16th June 2021

Application No: K/16/21/HH
Site Address: Sea Lodge 7 Coastal Road Kingston BN16 1SJ
Description of works: Internal alterations to existing dwelling. Demolition and replacement of existing rear extension with new single storey extension and first floor terrace above with external staircase. Replacement of main roof and 4no. new dormers with windows. Replacement roof tiles to single-storey projections on North elevation. Proposed rear single storey minor extension to garage to form entrance lobby. Alterations to external facade of house and replacement windows and doors throughout. Associated landscaping to suit.

Thank you for your internet representation made on 16th June 2021 which has been recorded as an objection with the comments as follows:

Project Coastal Road Drawing Proposed Second Floor	Project No. 2107 Dwg No. 3.102 Scale 1:100 @ A3	Rev Date Notes </
--	---	--

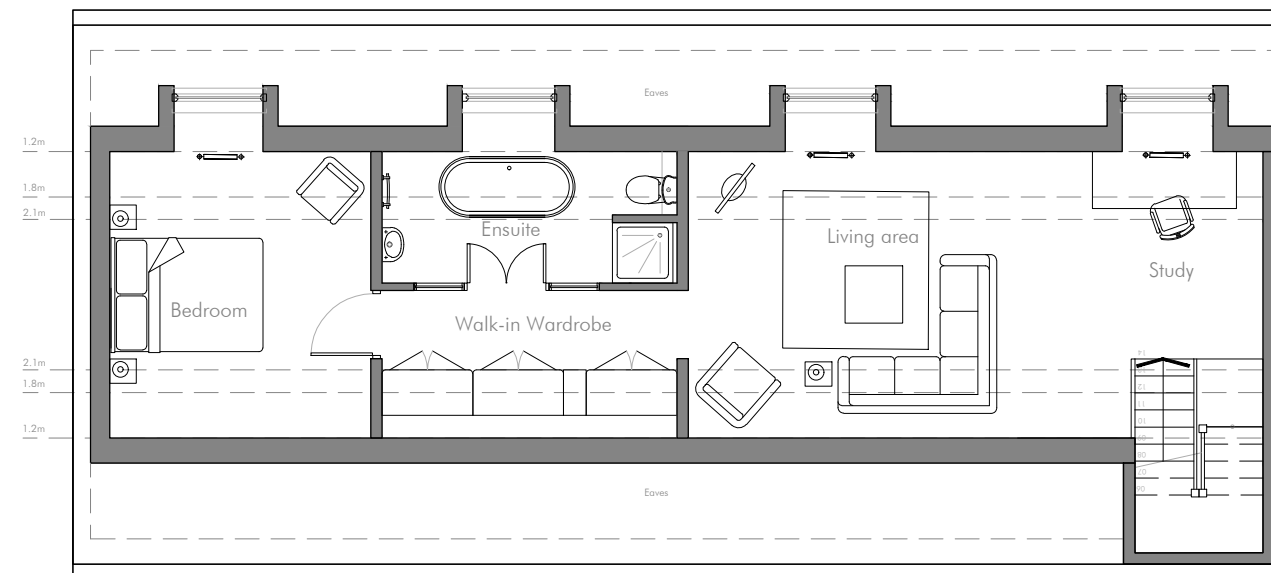
the additional one metre plus in height of the roofline and new bedrooms:

It will cause significant shadowing to my main first floor and ground floor terraces (which have seating and dining provision) as well as pose a clear invasion of privacy to both areas.

Both are used extensively and are currently not overlooked .
